File No: SF20/28709
Ref No: DOC20/247404

The Sandstone Precinct Stage 2 Modification 8 – Proposed demolition and construction works of the new Ausgrid Sub-station - Department of Education Building 35-39 Bridge Street, Sydney. (SSD 7484).

Thank you for your request for the Heritage Council to provide advice in relation to this proposed modification for the Sandstone Precinct –the Department of Education Building (SHR No. 00744).

Figure 7 | Proposed substation chamber, lower ground level (Source: MOD 7 Design Report)

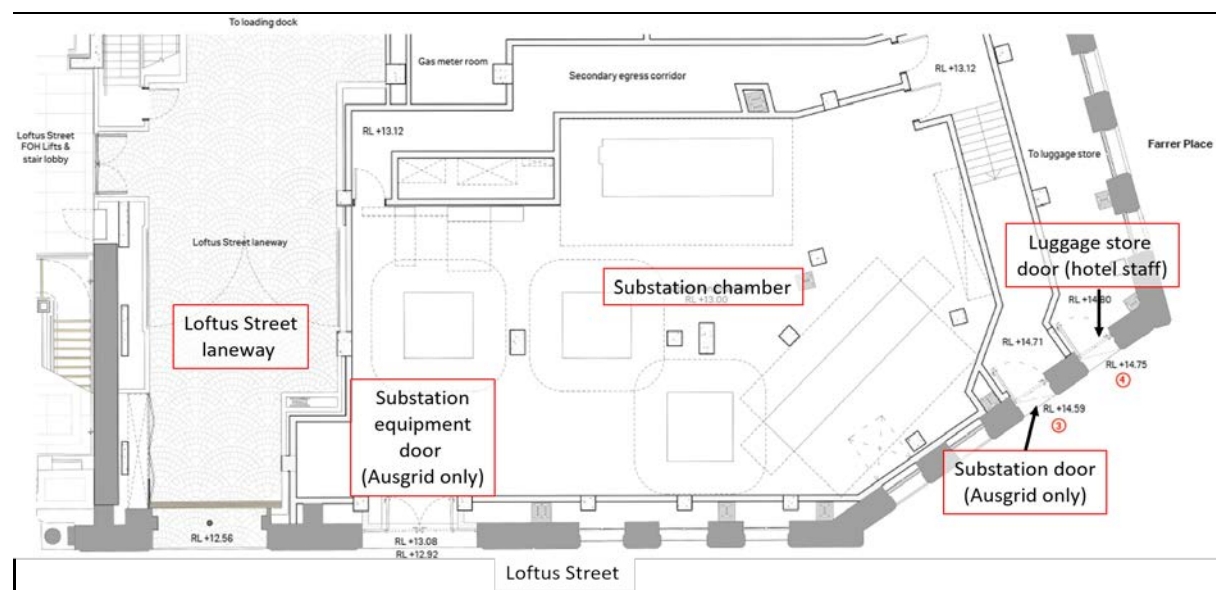
It is noted that some Exceptionally Significant fabric will be adversely impacted to accommodate the substation as required by Ausgrid, despite an options analysis and Dispensation options being discussed with Ausgrid. The current proposal has been chosen as the option with the least heritage impact. To mitigate this impact, and to meet the requirements of *CMP* Policies for Elements of Exceptional Significance (6.9.3 and 6.10.4), HNSW makes the following recommendations:

- the required modifications to the sandstone façade fabric and selection of new materials and colours to accommodate the substation must be appropriately detailed and implemented in consultation with and to the satisfaction of Urbis, the project Heritage Consultant, and
- any original sandstone fabric and steel window grilles required to be removed to provide access to the substation shall be salvaged and retained on site for future use.

this complex project. HNSW is satisfied that overall the proposed design changes are consistent with the development for which consent was originally granted and the modifications can be considered to have an acceptable material impact on the historic fabric of the building in the context of the approved major adaptive reuse works.
